Submission No.			277	
Organisation Name or Name of Submitter			Seatown Villas Residents, Swords North	
Item No.	Section Ref.	Page No.	Observation Statement	TII Response
Letter Re: MetroLink Order 2022 Estuary to Charlemont - Seatown Villas Residents Submission 18/11/2022.				
1	2. Linear Park	4	<p>We have requested in the form of RFIs through our technical representative (RINA the Independent Engineer) for the "Technical Support" to support the concept of the Linear Park. To date we have received no documentation as to the advantages for this aspect of the Metro.</p> <p>Seatown Residents along with Ashley Estate and Estuary Court have serious concerns with the design and the need for penetrations into our estates through the existing substantial walls that presently separate our green from the very busy R132 road.</p>	<p>The independent Engineer (RINA) report which was issued to the stakeholders contains reponses to RFI's.</p>

Client	TII NTA	Project	METROLINK	Drawing Title	METROLINK - STRUCTURES SEATOWN STATION PROPOSED STREET LEVEL DESIGN	Drawing Status	S0
Consultant	JACOBS IDOM	Drawing N°	ML1-JAI-SRD-ROUT_XX-DR-Y-02006	Plan Drawing N°	ML-ST 301 K-L1	Sheet 1 of 5	
		Scales Original Size A1	1:250

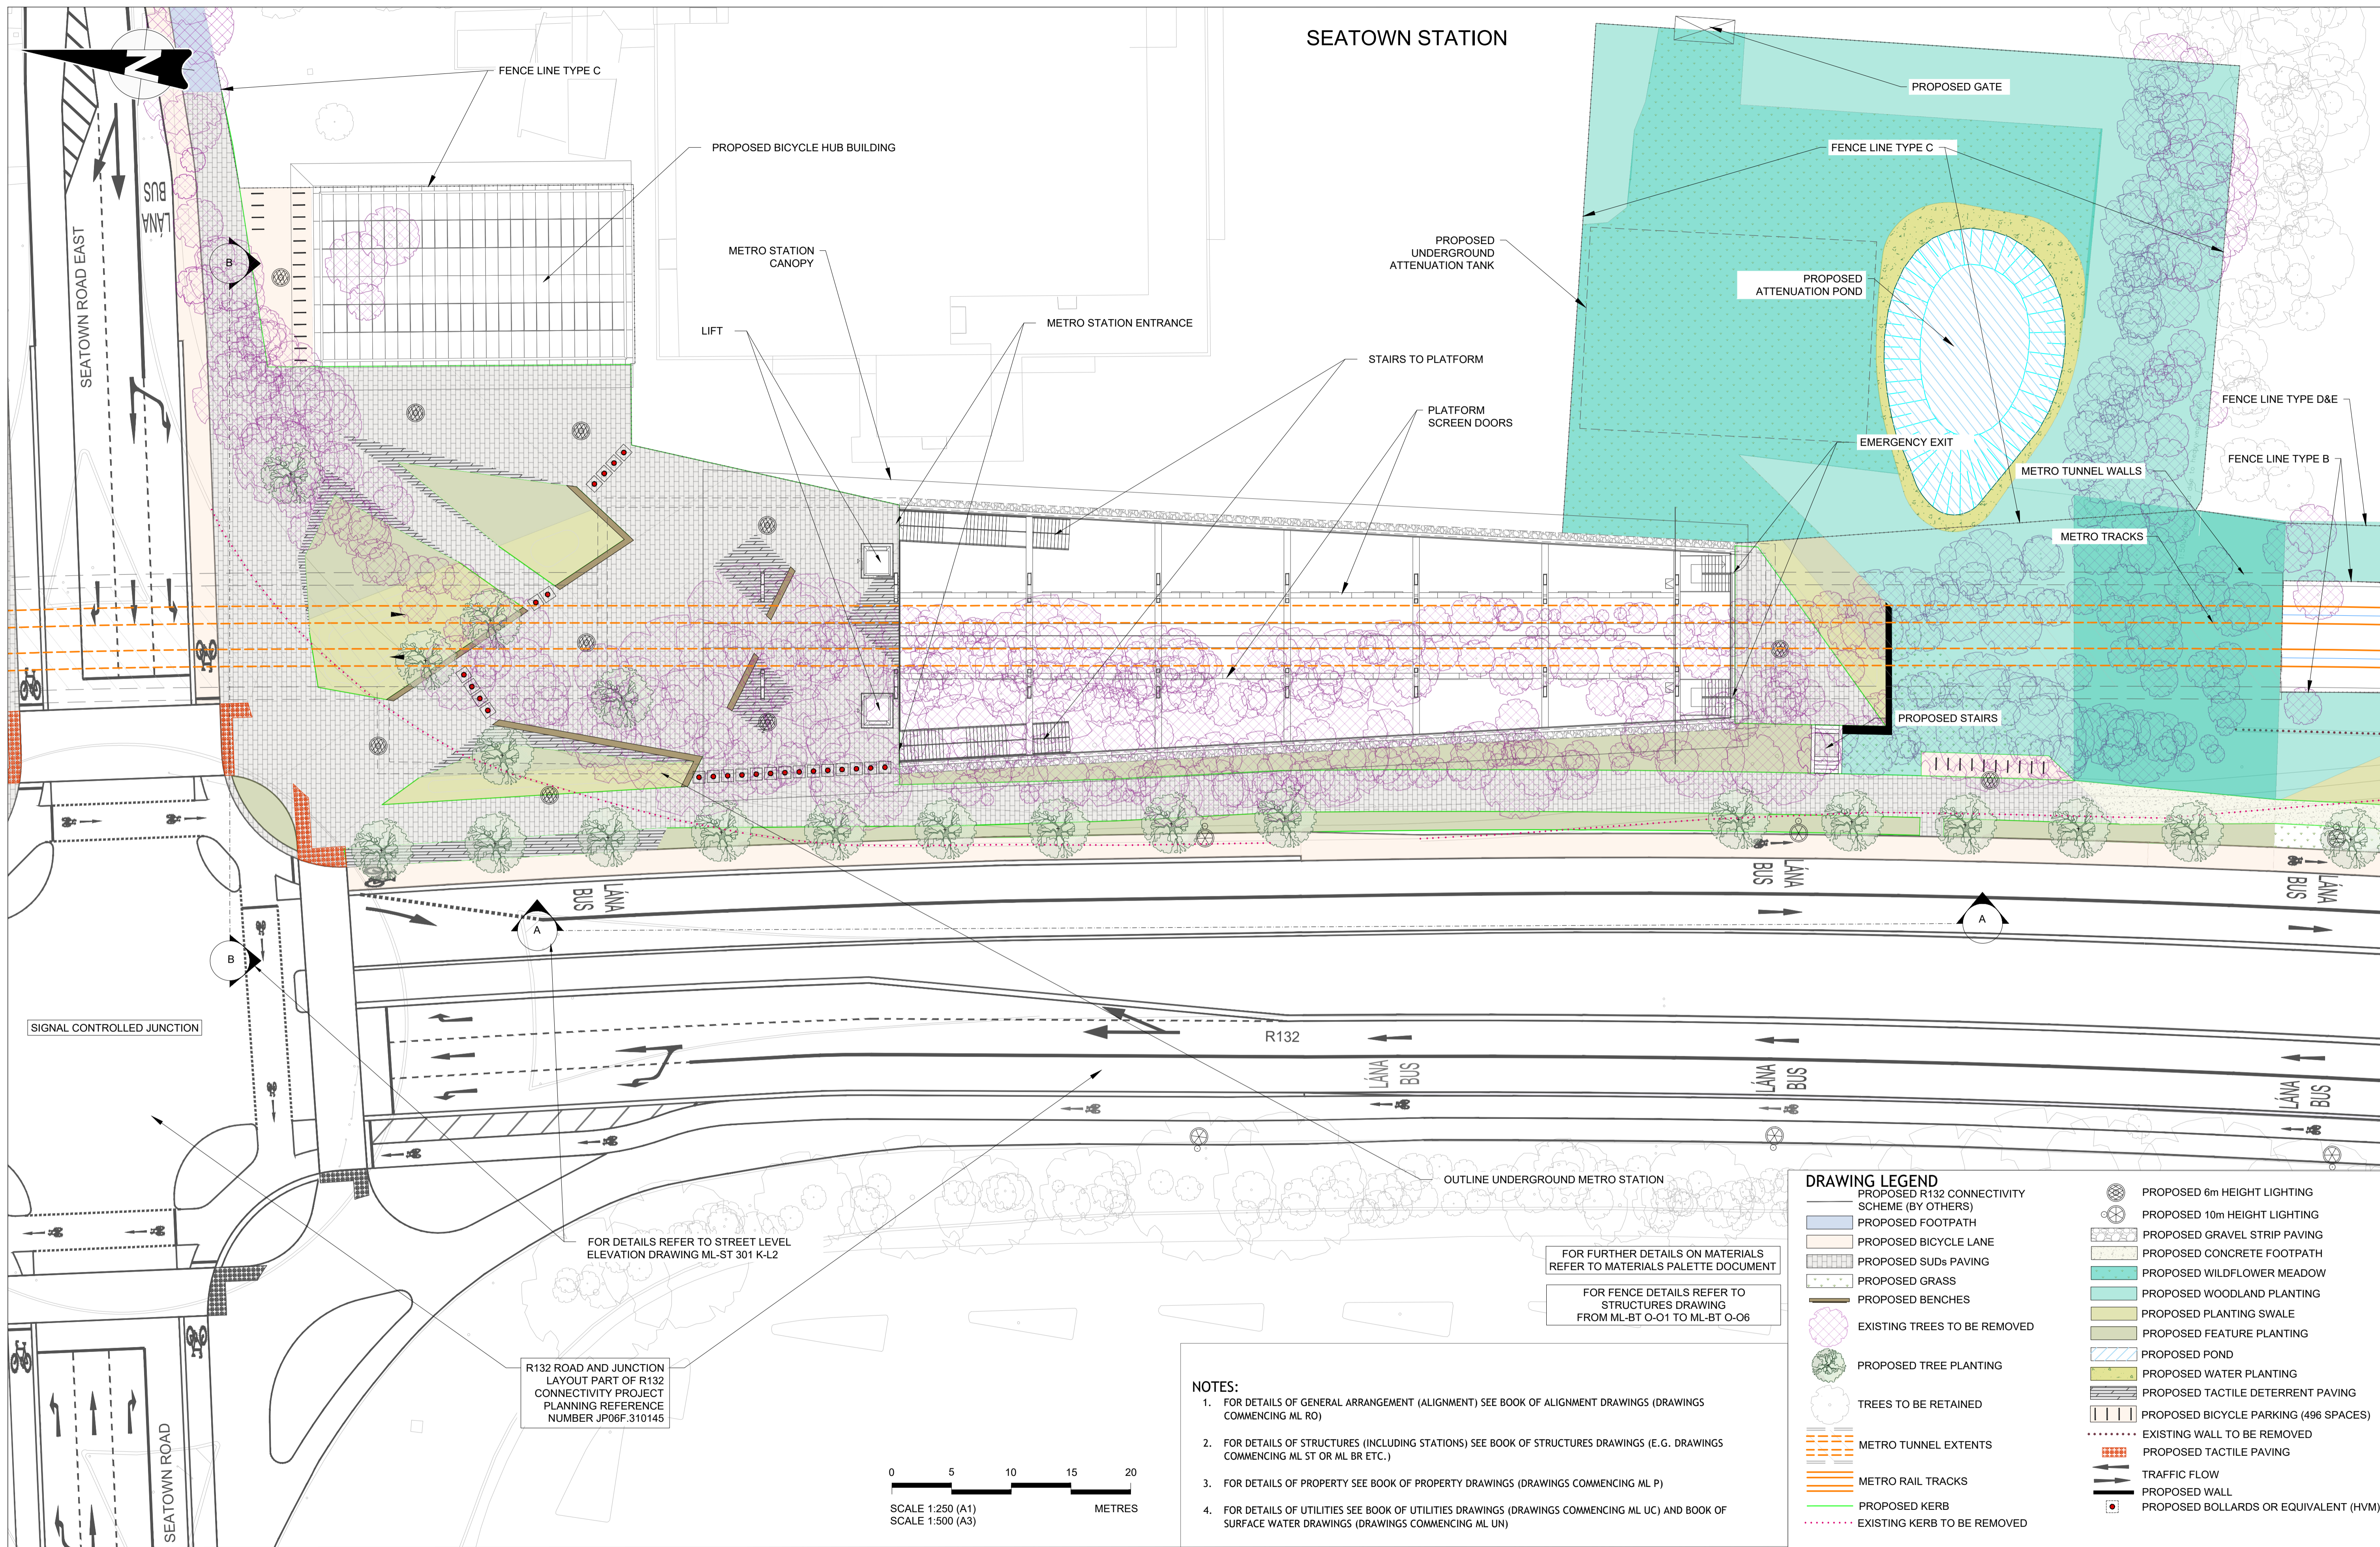
6	3. Construction Compound	7	...highlighted areas (Fig 3.2) for consideration as alternatives to compounds in residential estates, there seems to be any number of potential areas right beside the proposed Seatown station, Why is it the preference of TII to encroach on Residential land for this purpose as opposed to commercial / industrial designated land ?	<p>Details of the requirements and provision of Construction Compounds are given within section 5.3 of the EIAR Chapter 5: MetroLink Construction Phase.</p> <p>Volume 4 Figures, Chapter 5, Metrolink Construction Figure 5.1 Construction Compounds provides details of all the proposed sites along the alignment, noting that the vast majority, with two exceptions, are positioned in "commercial/industrial" designated land.</p> <p>The Satellite compound designated at Seatown West, opposite the residents from Seatown Villas will be required for 33 months (see response number (3) above) to undertake the main MetroLink works within the boundary of the site at this location, including:</p> <ul style="list-style-type: none">- The cut & cover and retained cut structures.- The Drainage Pumping Station in land on the corner of the R125 and Seatown.- The reinstatement of the agreed landscape on the completion of the alignment structures.

Project	Drawing Title	Drawing Status
Estuary - Seatown Landscape Layout Preliminary Design Issue		S4
Drawing N°	ML1-JAI-ARL-SC01_XX-DR-Y-00001	
Scales Original Size A1	1:1000	Sheet 1 of 3

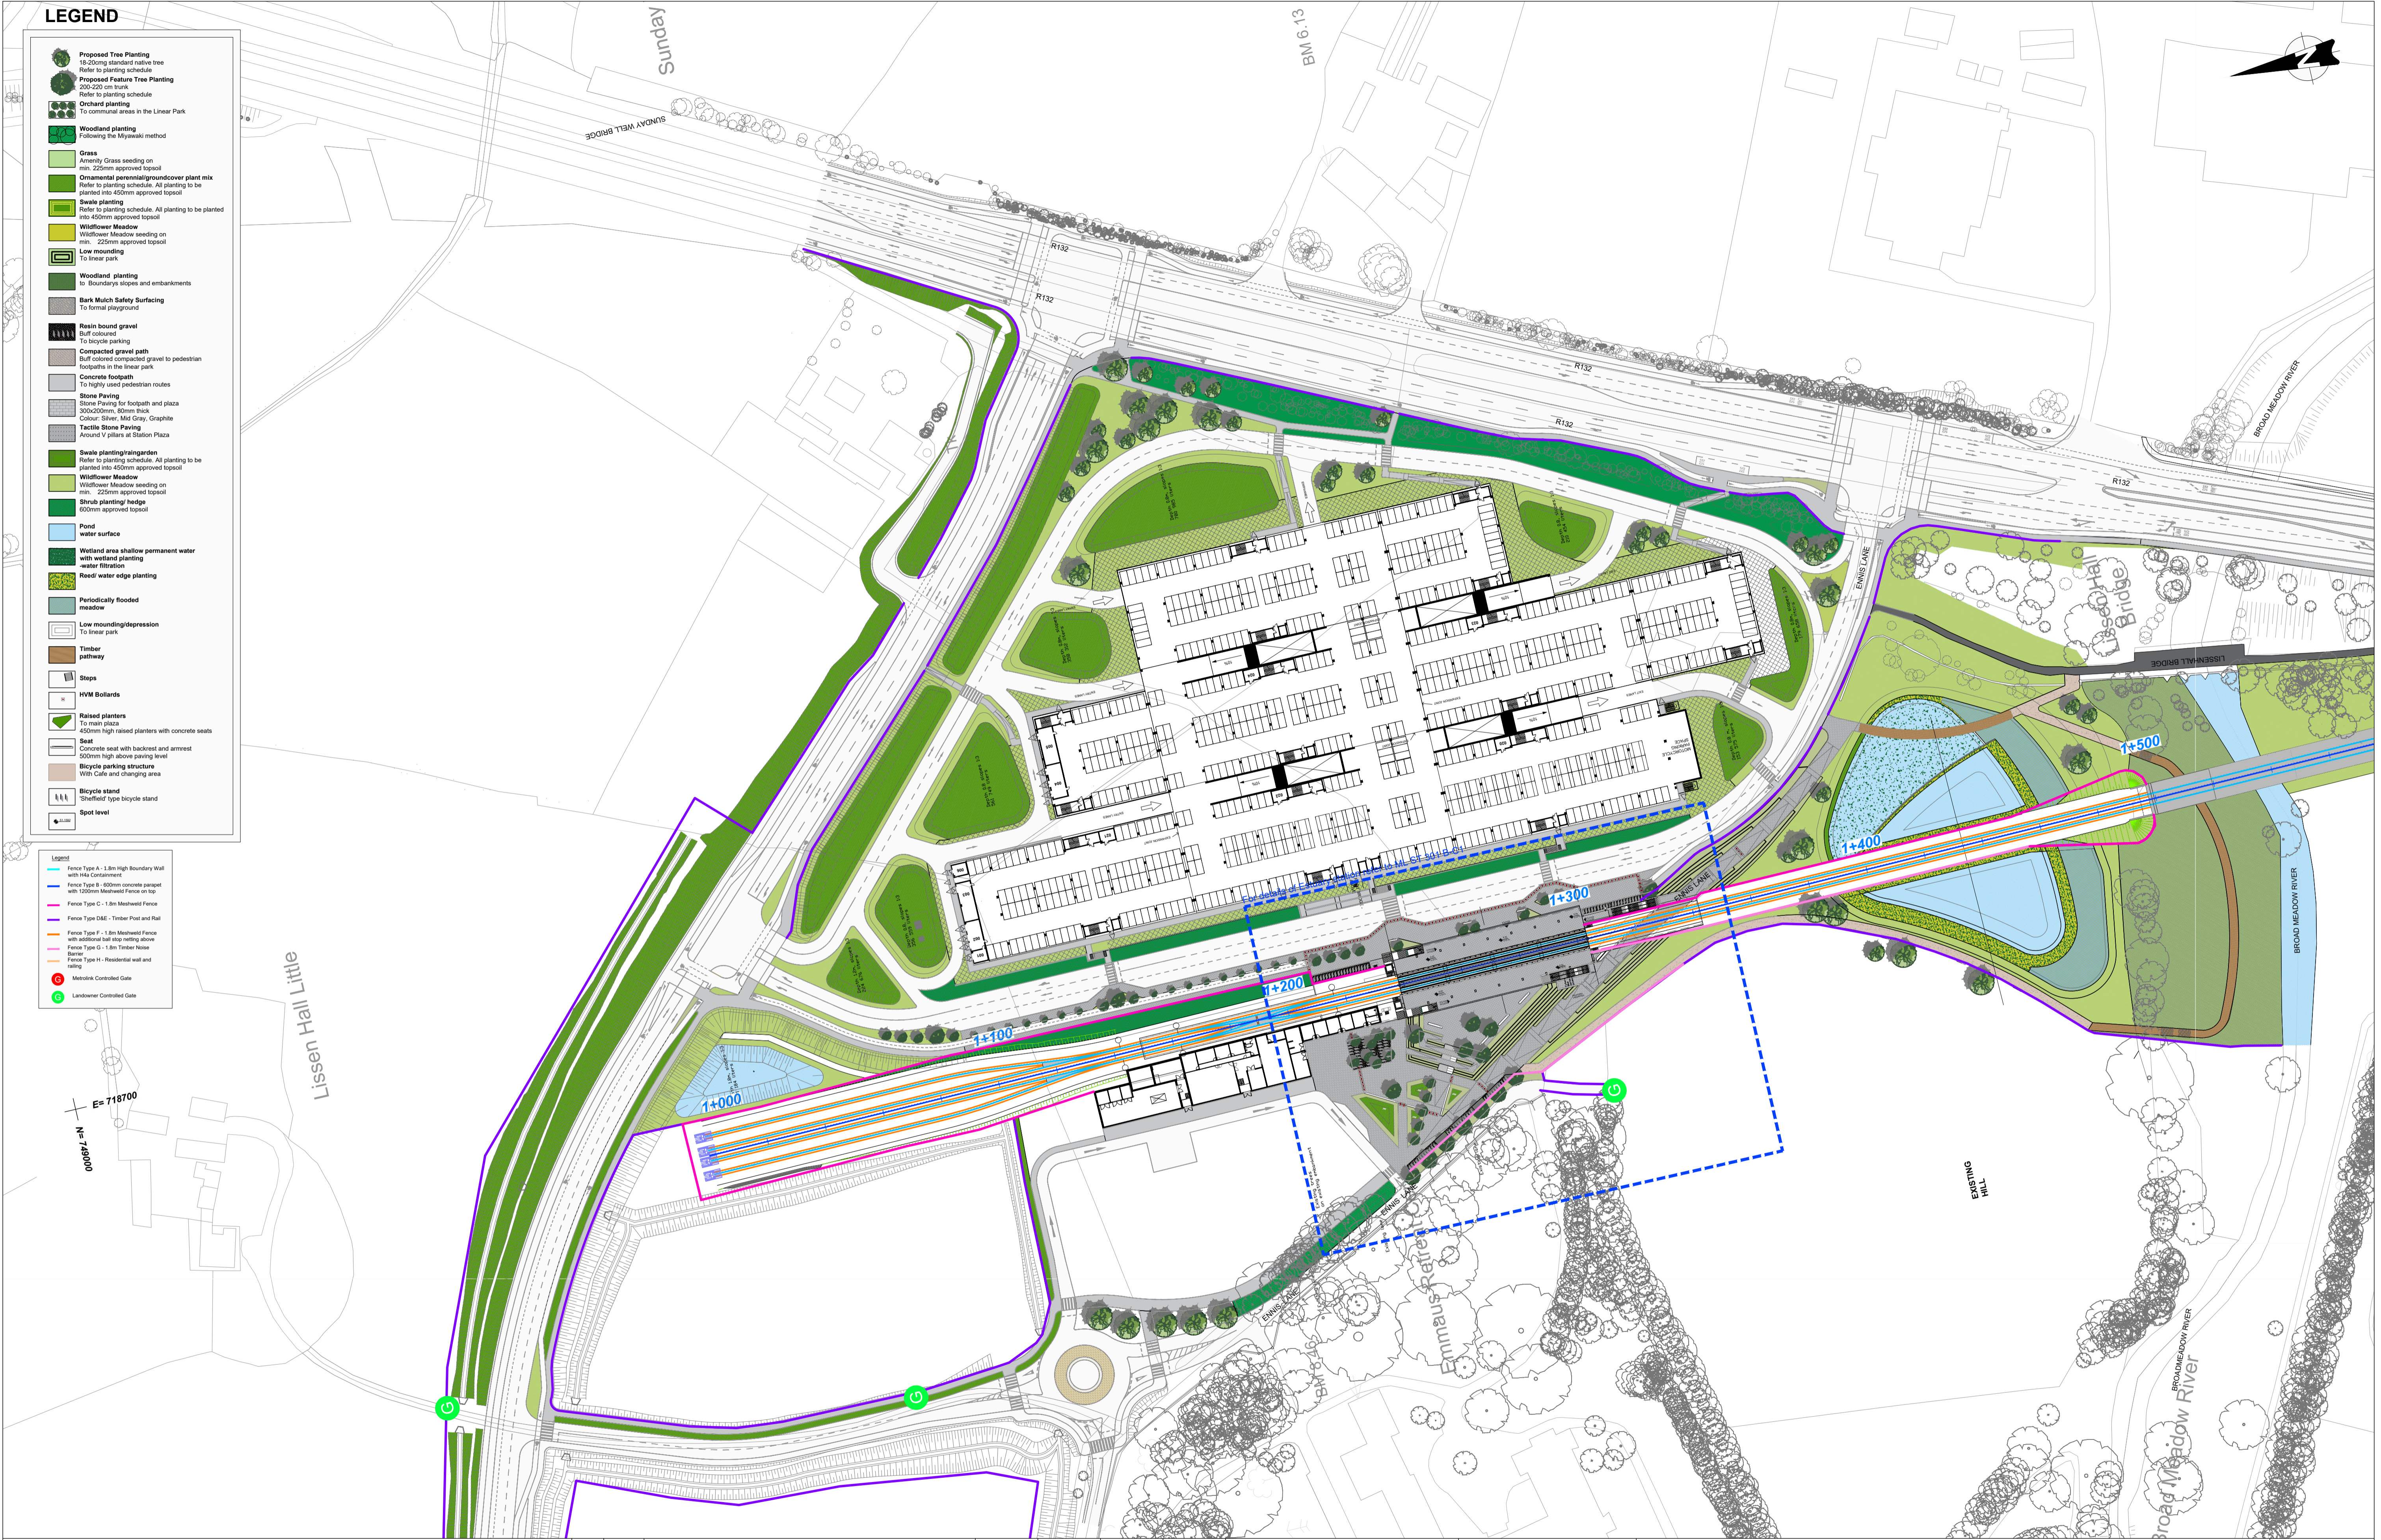
10	4. Preferred Route Alignment	8	In addition to the above we also have serious concerns that the "preferred route" alignment will have a negative effect on the environment as it will be necessary to cut down a lot of mature trees to facilitate the "cut & cover "option, this in turn will increase both airborne pollutants as well as noise pollution as the trees along both sides of the R132 have been positively impacting the effects of these for over 30 years	Further to response number (1) and (4) above. As currently detailed within the EIAR, the proposed Project will provide an integrated series of small local parks complete with play facilities, seating and planting, adjacent to the residential areas and which interconnect to form part of the longer green ribbon proposed alongside the Fingal County Council's consented R132 Connectivity proposals. The extensive landscaping is proposed for over the cut and cover sections and linking around open cut sections, following the alignment but also extending into existing open spaces as appropriate in order to provide a comprehensive recreational facility for the adjacent residential communities. The nature of the proposed planting is biodiverse and will mature to provide a much more valuable, connected landscape than is currently the case. The proposed tree planting will be much more appropriately scaled to the adjacent residential open spaces than the existing predominant tall roadside trees. This proposed section of the R132 extensive landscaping, which is being included as an integral part of the proposed Project within this Local Landscape Character Area (LLCA), will beneficially transform the interconnectedness of this area, across and along the road and with the range of local communities and facilities around the eastern side of Swords. This is particularly so for pedestrians and cyclists. It will represent a significant positive effect of the proposed Project in respect of its broader landscape context and in terms of social and cultural amenity for the town of Swords and its environs. It also represents a major enhancement of the existing landscape condition.
